Response for deadline 6 – matters arising from ISH3

Planning Inspectorate ref: EN020026

Executive Summary

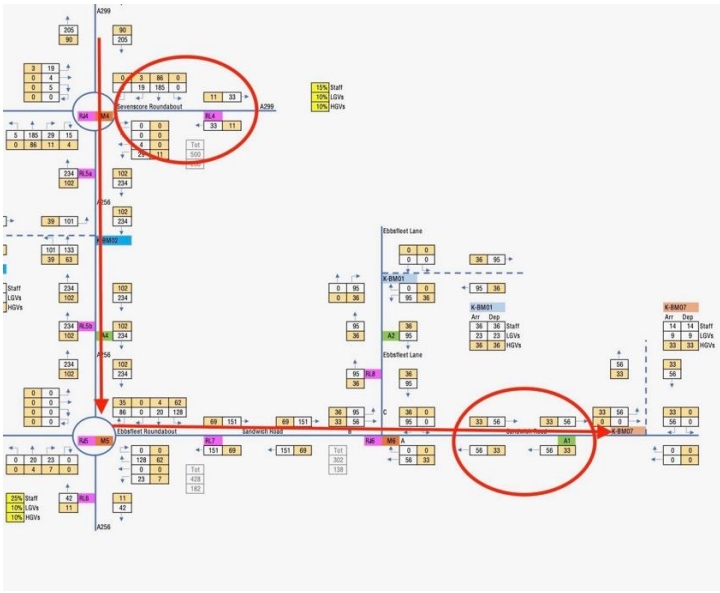
- a) In APP-181 Traffic Flow diagrams 12hr weekday (07.00-19.00) on the next page shows 90 HGVs (and 205 other vehicles) using the A253 whereas in APP-266 HGV routing map it shows HGVs using the A299 not the A253.

Is this a simple transcribing error or does the Applicant need to redo the Junction Modelling Capacity for K-RJ1?
